Engineers Comments Regarding Surface Water Drainage

Application Reference:	M/20/26/PL	Reviewer Reference:	ADC/KW/PC
Planning Officer:	Harry Chalk	Date of Review:	24/04/2026
Site Name:	86 Ancton Way Elmer PO22 6JP		
Application Description:	Demolition of existing bungalow and construction of replacement dwelling (resubmission following M/58/25/PL).		
Assessment Number:	1

TYPICAL LONGITUDINAL SECTION THROUGH RAIN GARDEN
Scale 1:20

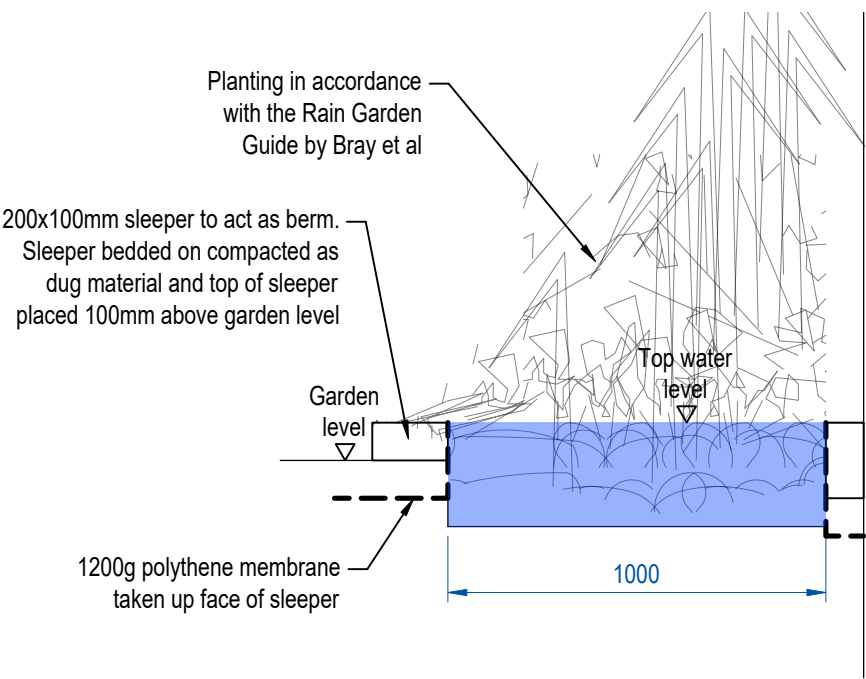
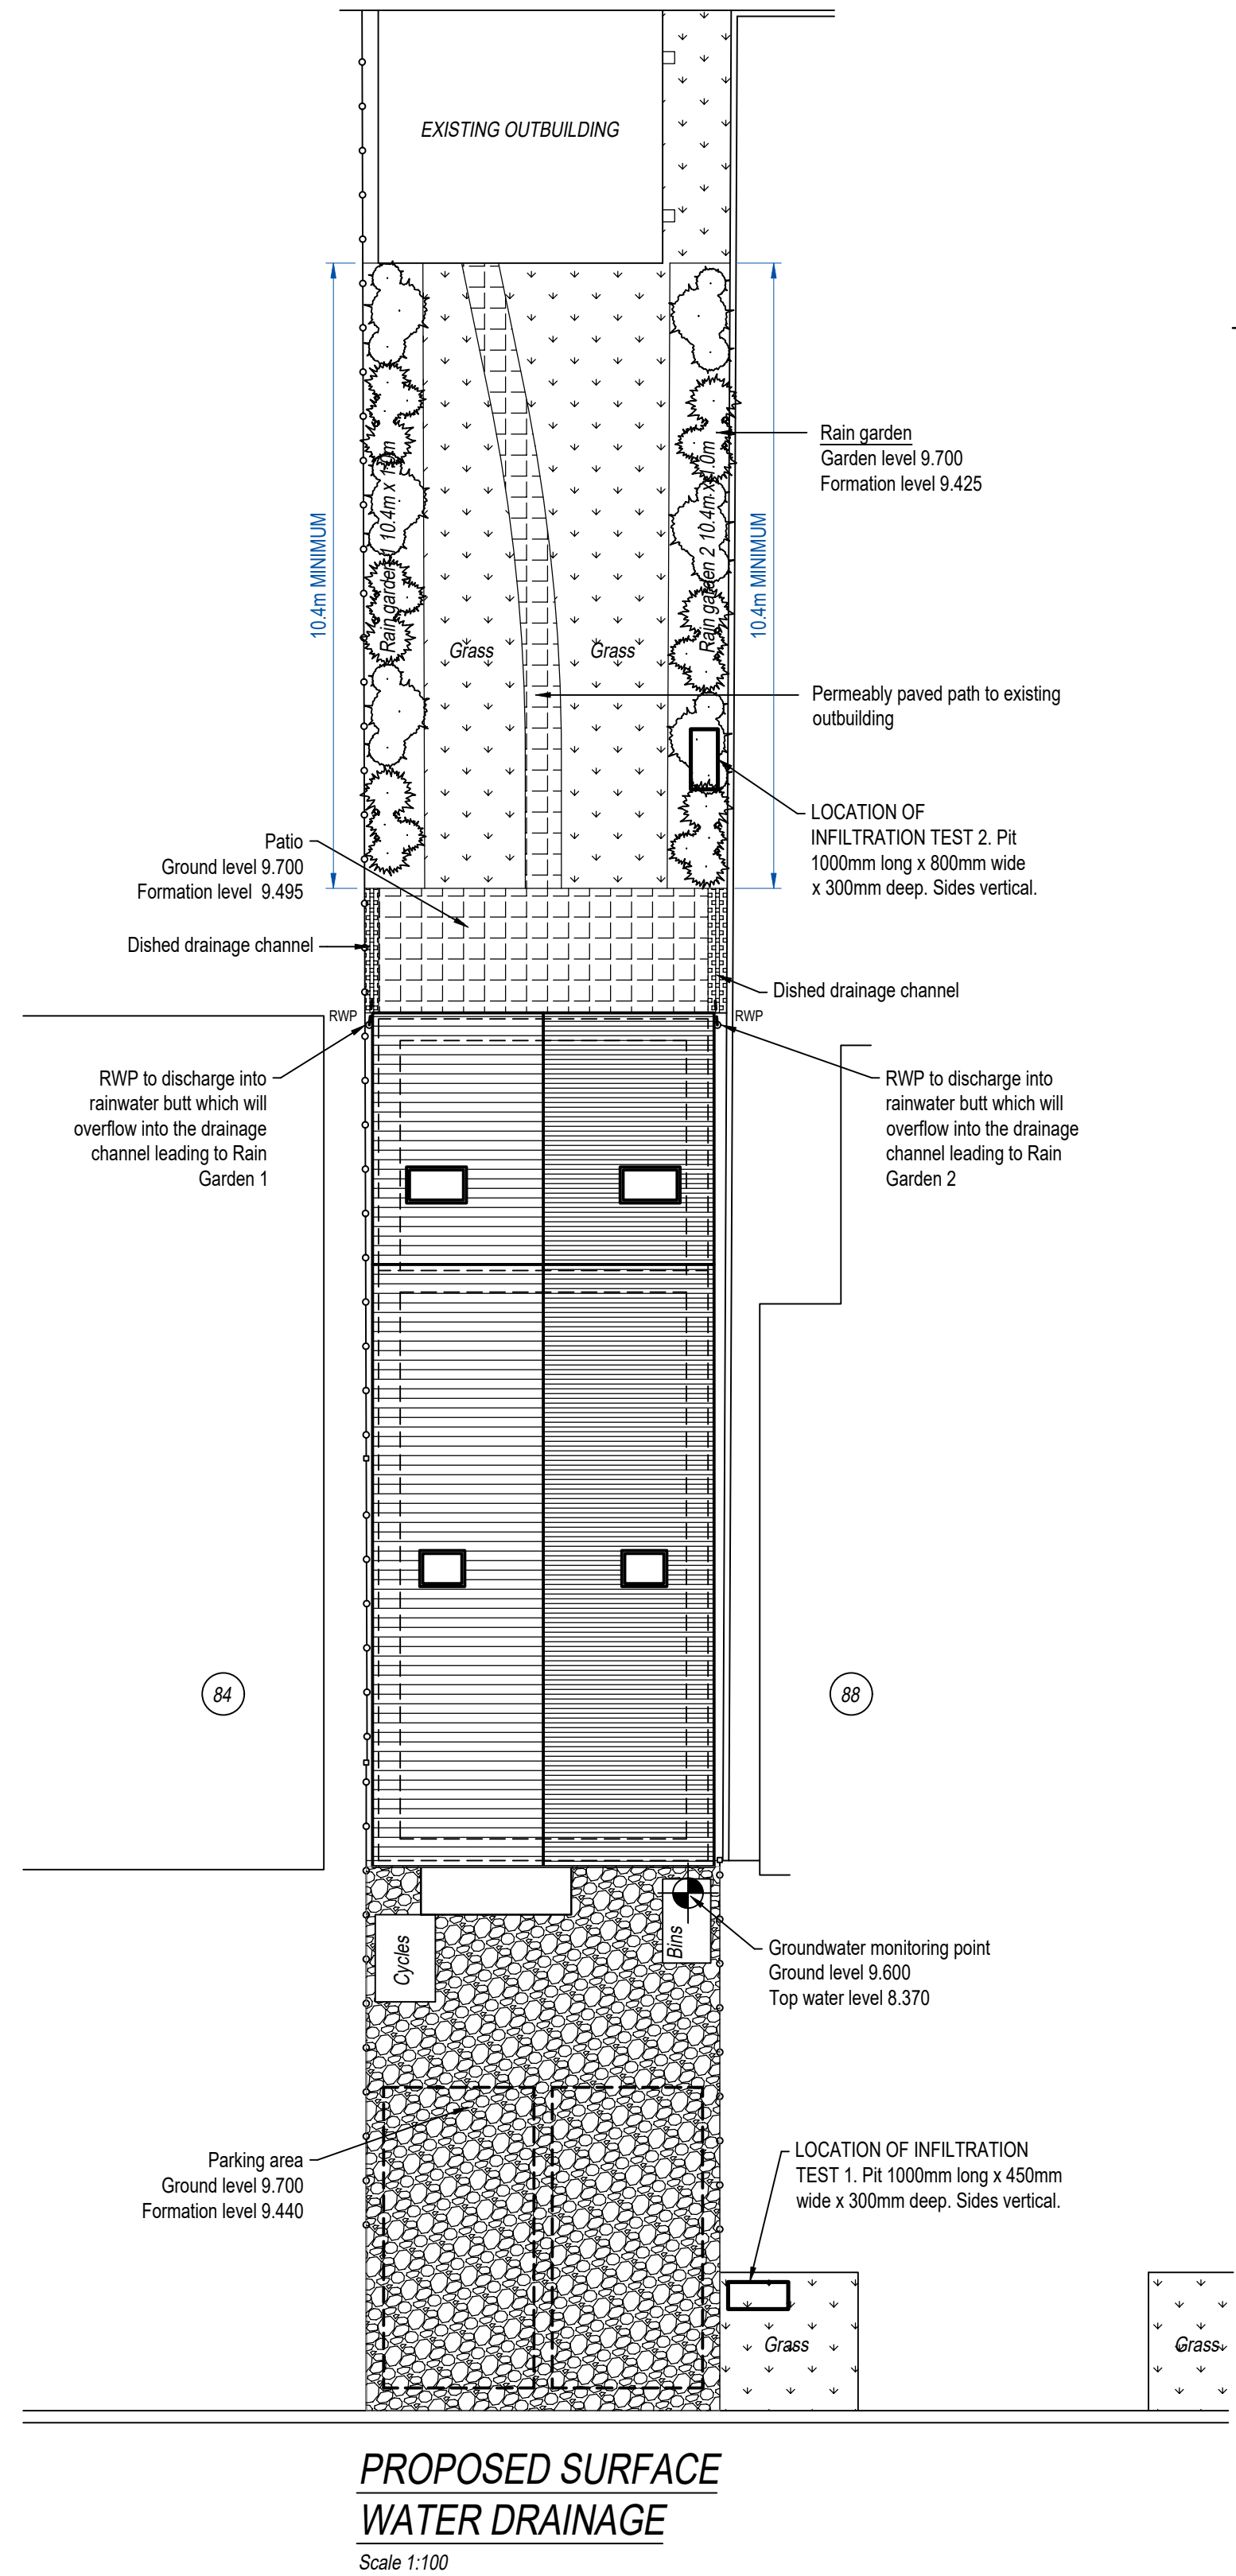
- 1.3. The stated porosity of the proposed rain gardens appears to be excessively high. A void ratio of approximately 95% would typically be associated with a proprietary crate or modular attenuation system. However, the proposed rain garden incorporates a soil or substrate growing media, which would be expected to have a significantly lower void ratio. A site-specific porosity value should therefore be applied, taking account of the characteristics of the proposed planting media and the anticipated reduction in available storage volume over time as the planter becomes established and matures. The applicant is recommended to contact the ADC Engineers to discuss a suitable value prior to re-submitting further information for consultation.

- 3.1. The site is entirely within Flood Zone 3a. It is now proven by Product 4 data that the site is only affected by tidal flooding. SuDS are compatible in such areas. Further guidance on designing SuDS in tidal areas can be found at www.arun.gov.uk/surfacewater.
- 3.2. As noted in Standard 1, it is considered the potential porosity of the raingardens has been over estimated, further details would be required to demonstrate that sufficient storage is provided within the proposed SuDS features.

- 1.1. The designer proposes to drain the roof area of the new dwelling into two rain gardens running alongside both side boundaries via rainwater butts. All other hard surfaces, including the driveway, are to be of permeable construction. We are supportive of the use of infiltration as the second-highest priority disposal option (after water reuse). Two shallow infiltration test pits have been tested in accordance with industry guidance; these are shown on plan and positioned in the front and rear gardens. The slowest infiltration rate calculated was $2.9 \times 10^{-5} \text{ m/s}$. This is the rate that has been used to inform the SuDS design.

- 1.2. The design positions the permeable paving to the rear and the rain gardens at no lower than 9.425 m AOD, and the drive to the front at no lower than 9.440 m AOD. This is above the minimum allowable level of **9.370 m AOD**, as evidenced during the compliant groundwater monitoring undertaken in 2024/25. This is acceptable.
